Building Inspections - RE: 42 Seal Cove Ln.

The owner made some changes to the plan and we are filing the attached amended set of plans.

East Elev

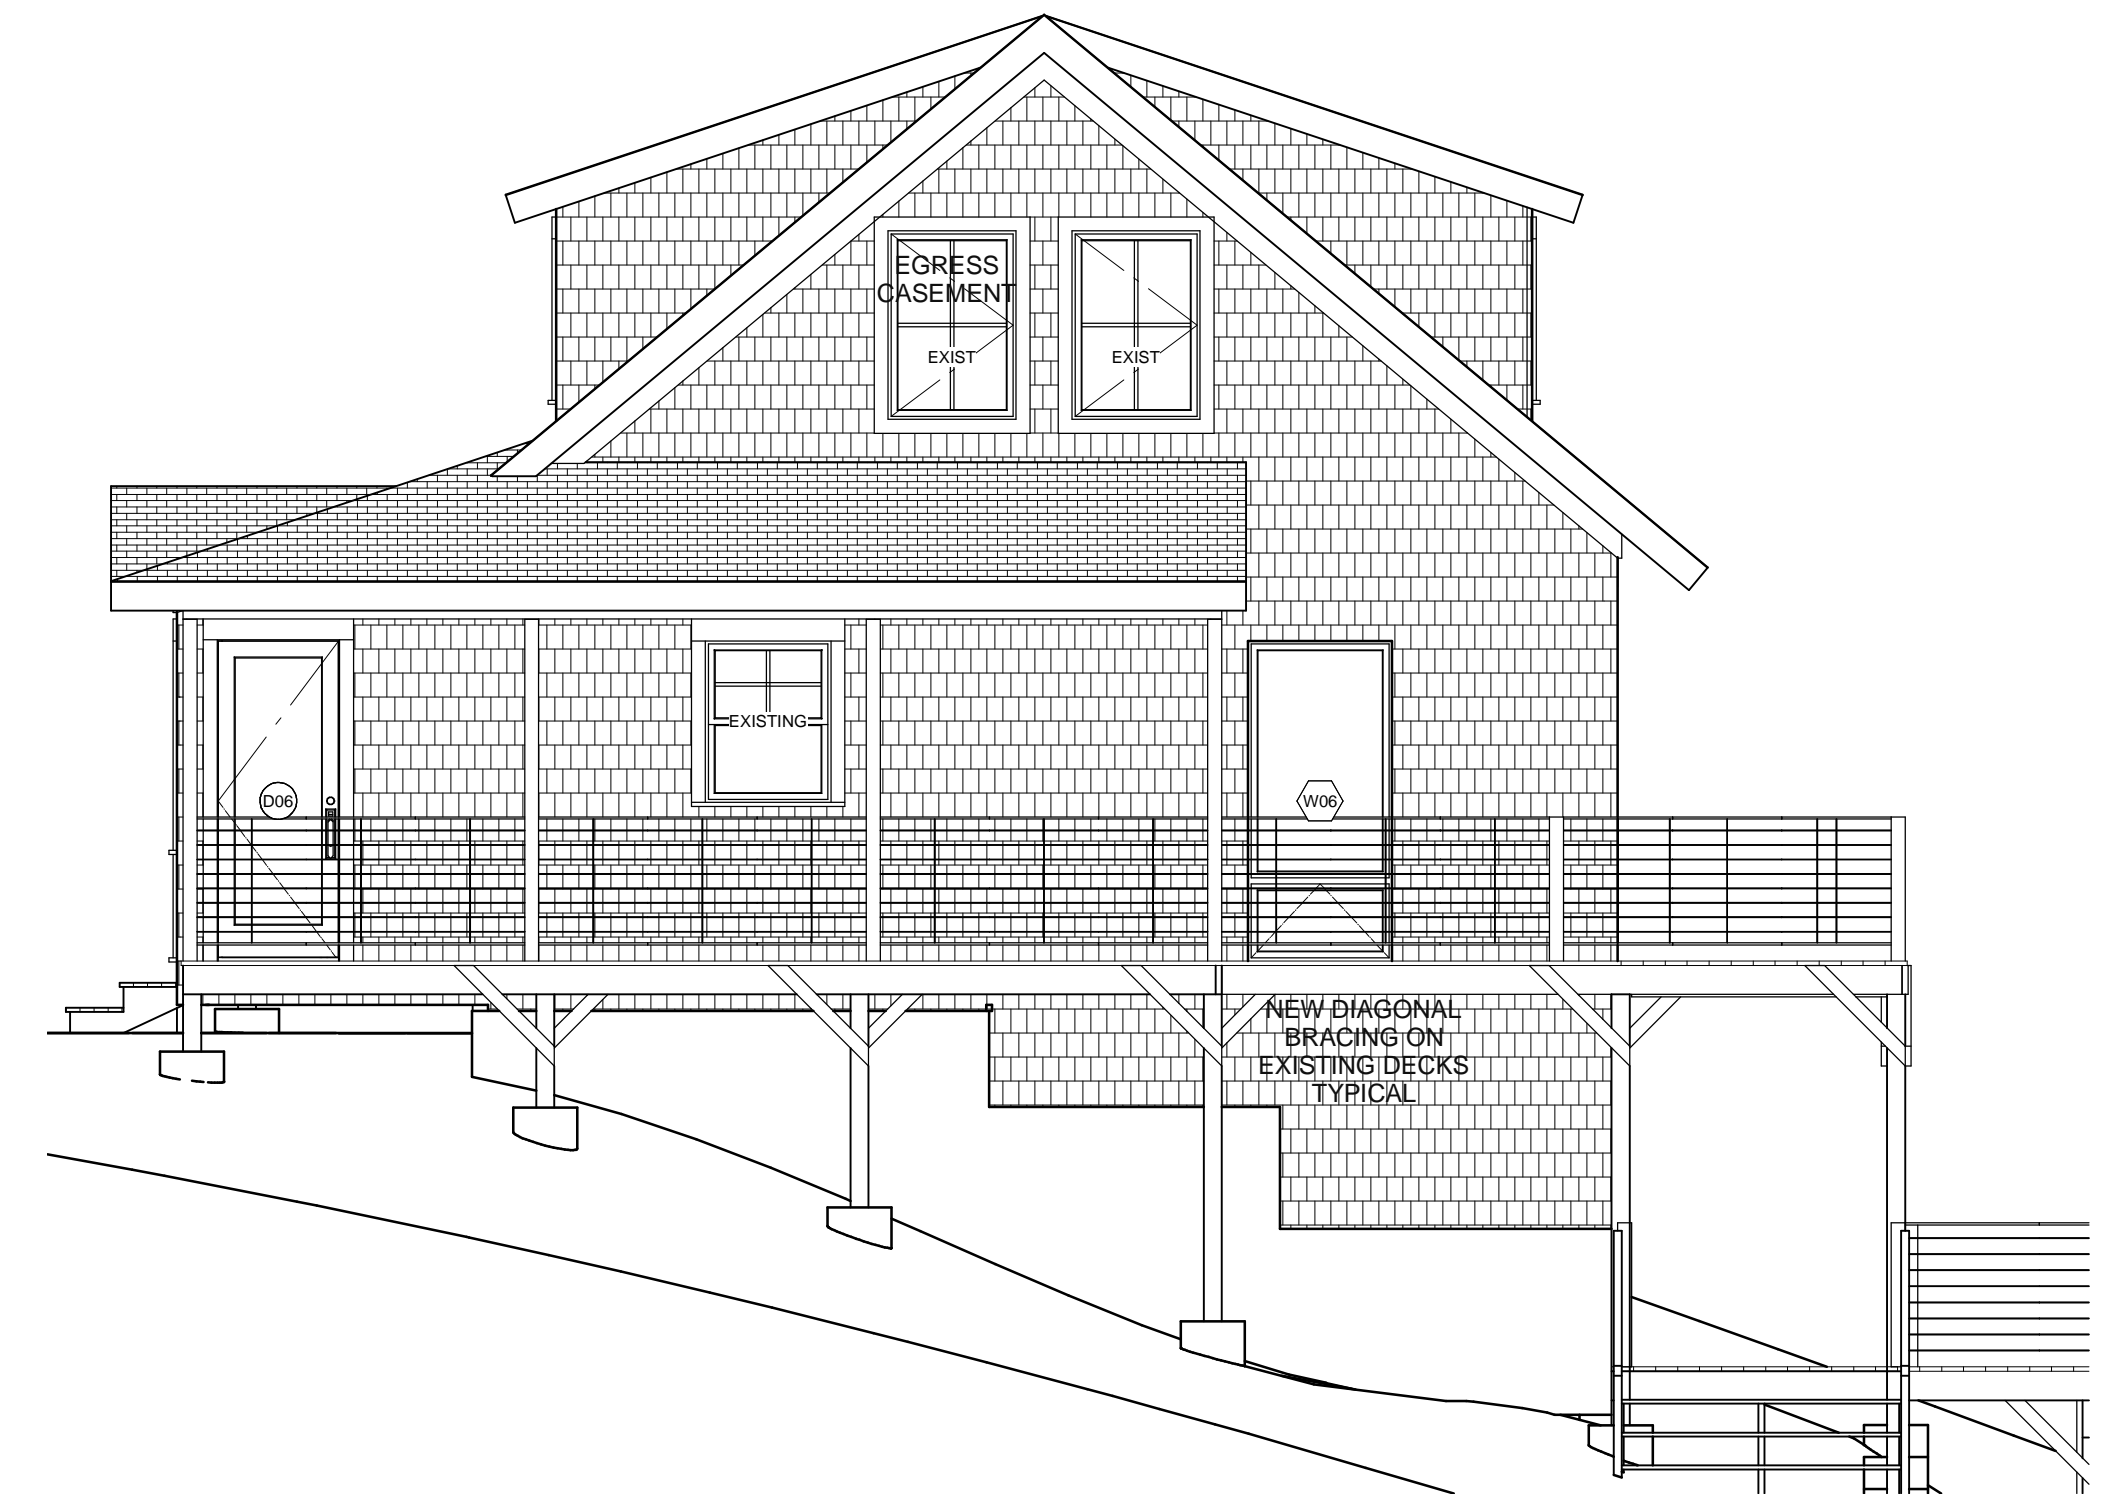
1. Enclosing the porch on the west elevation and putting a foundation under the existing roof.
2. Adding a small gable to the roof over the entry.
3. Leaving the existing porch on the main level on the east and north elevations.
4. Increasing the size of the deck on the South elevation.
5. Increasing the size of the deck on the ground level on the West elevation.
6. Moving the existing kitchen to the North-West Corner
7. Moving the bathroom to the enclosed porch.

<b>Site Plan</b> 1" = 10'-0"	<b>C9-001</b> 5/23/2013 1 of 6
---------------------------------	-----------------------------------

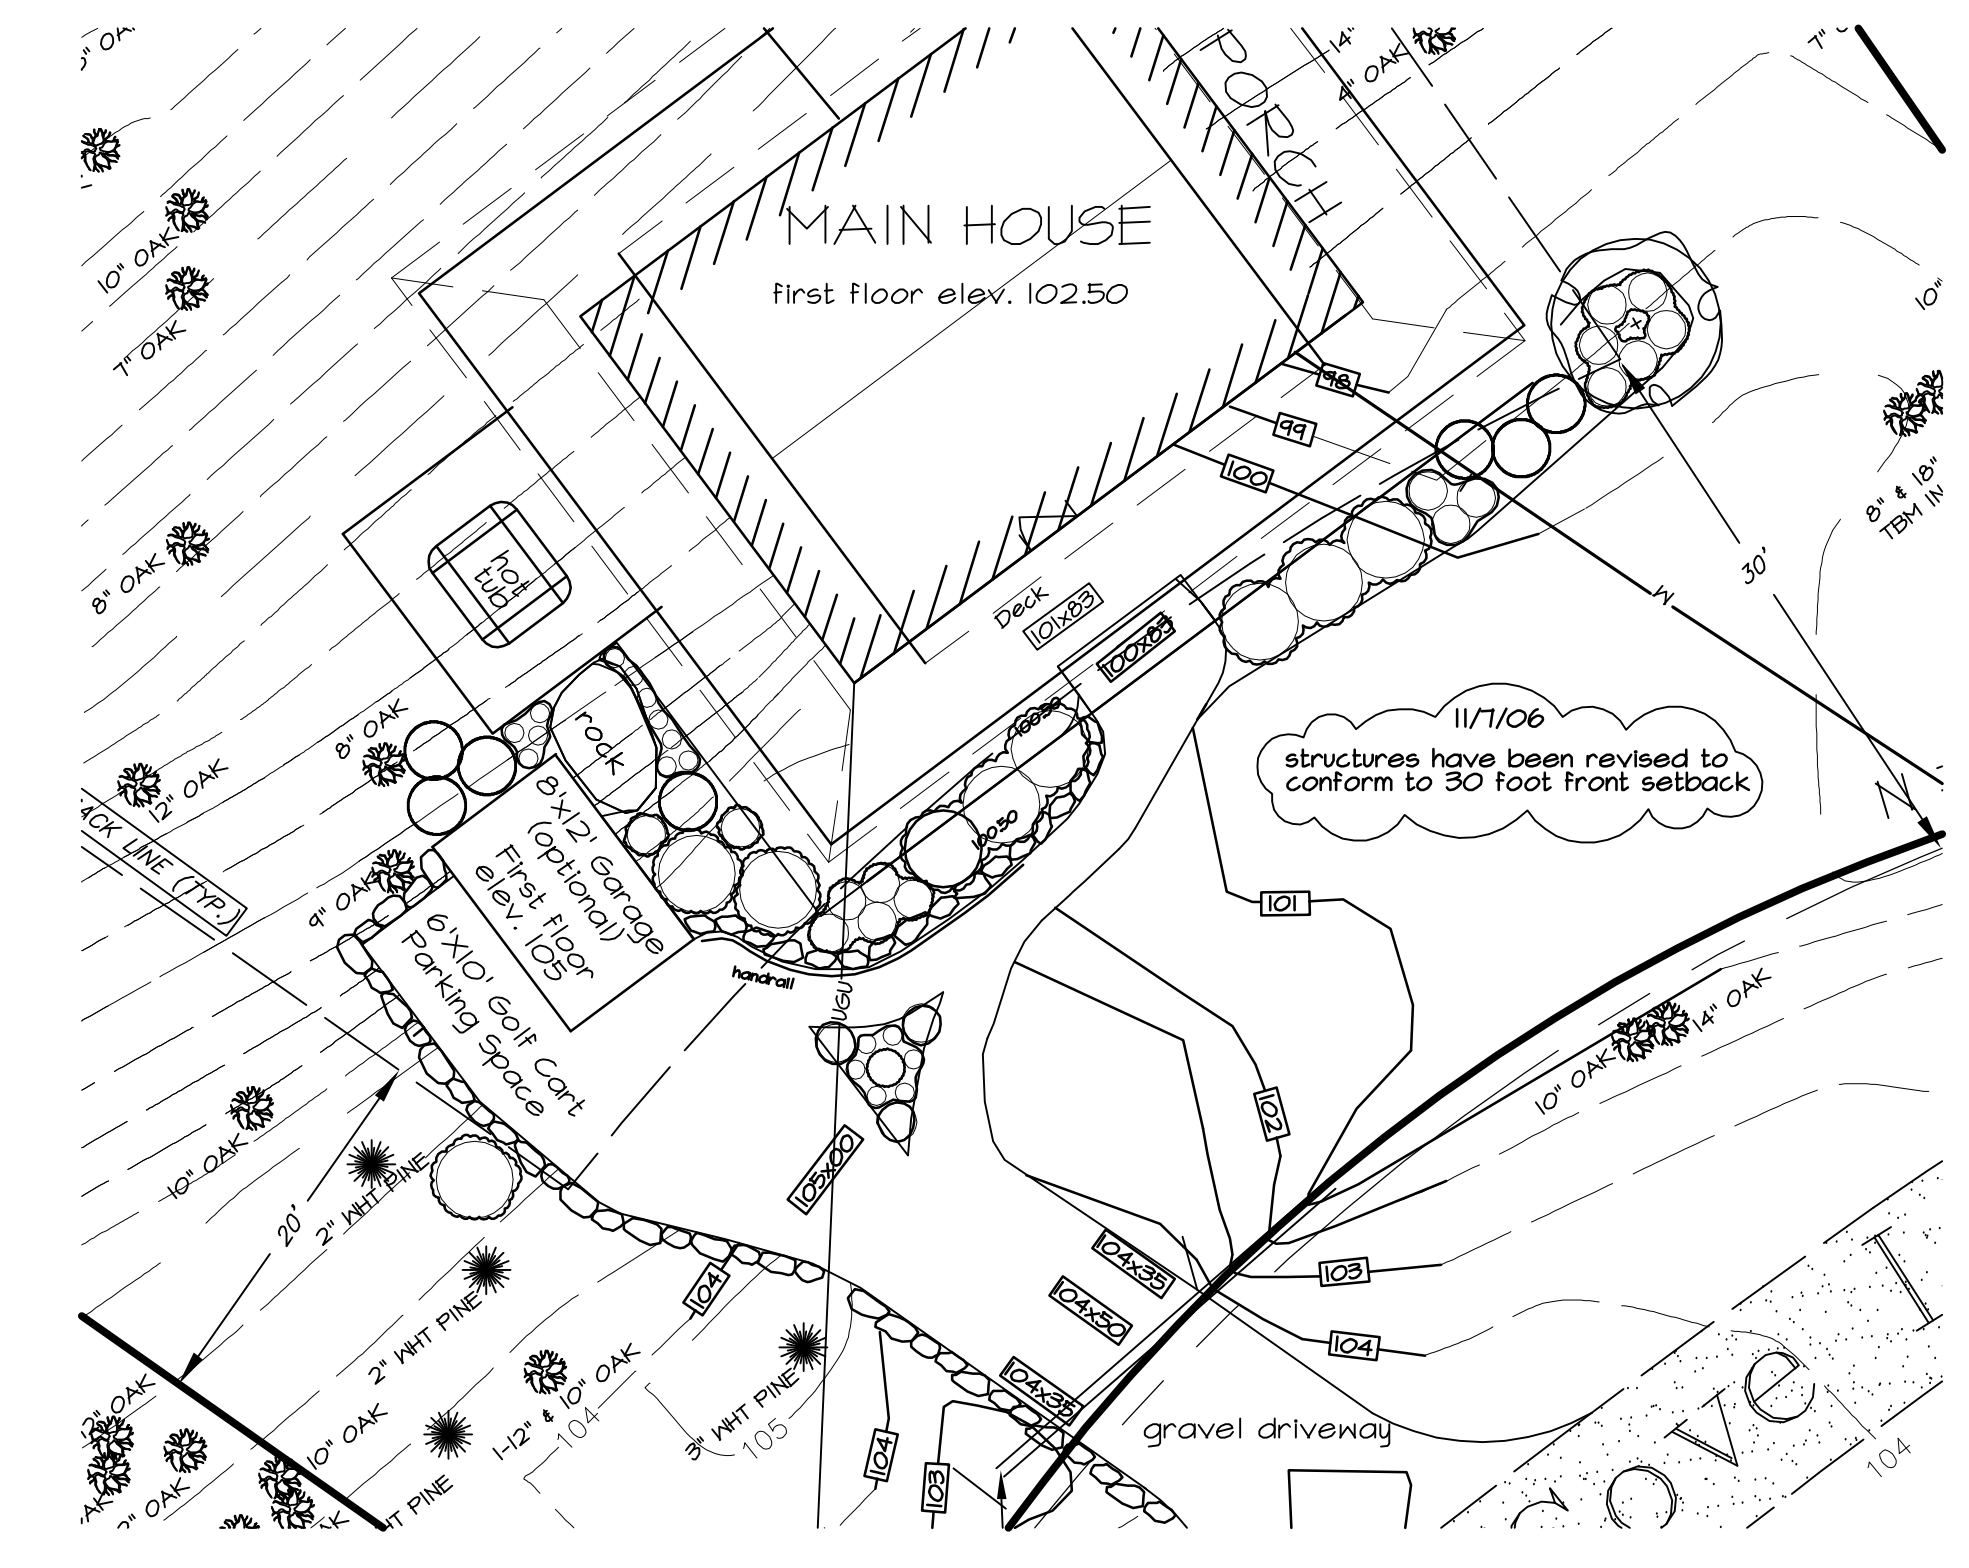
Morning. I'll upload the proposed changes. Zoning Administration, and Fire Prevention will need to review the footprint expansion(s) as-well.

The expanded decks are within the setbacks.
